Re: Status of Improvement Permit Application #14-5-34599

James E. Manhart, III, R.E.H.S.
Environmental Health OSWW Specialist
Harnett County Department of Public Health

SITE PLAN APPROVAL
DISTRICT RA 40 USE SFD
#BEDROOMS 4
9-15-14 J. E. [Signature]
Date Zoning Administrator

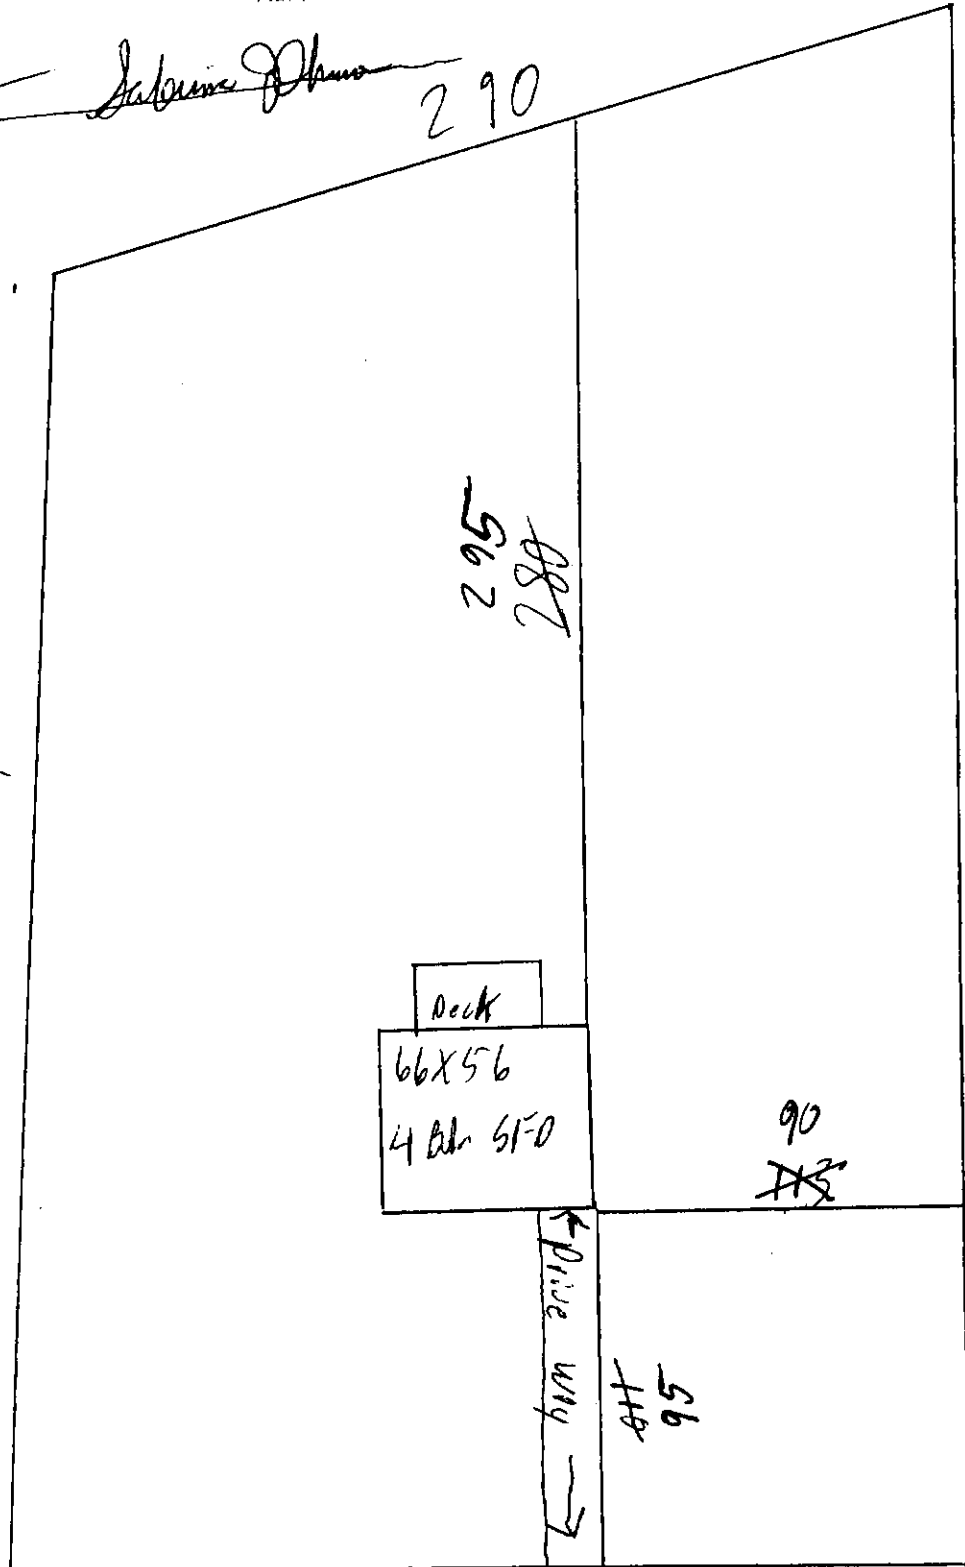
- 1. Use pink flags to mark property lines and irons that are set by surveyor need to be visible (*\$25.00 fee incurred*)
- 2. Use orange flags to mark house corners (*\$25.00 fee incurred*)
- 3. Directions not clear to property (*\$25.00 fee incurred*)
- 4. Property needs only brush or vegetation removed
- 5. Driveway not shown on site plan
- 6. Backhoe pits required
- 7. Other – Setbacks for proposed home are incorrect. Please measure and revise your site plan. Submit changes to Central Permitting.**
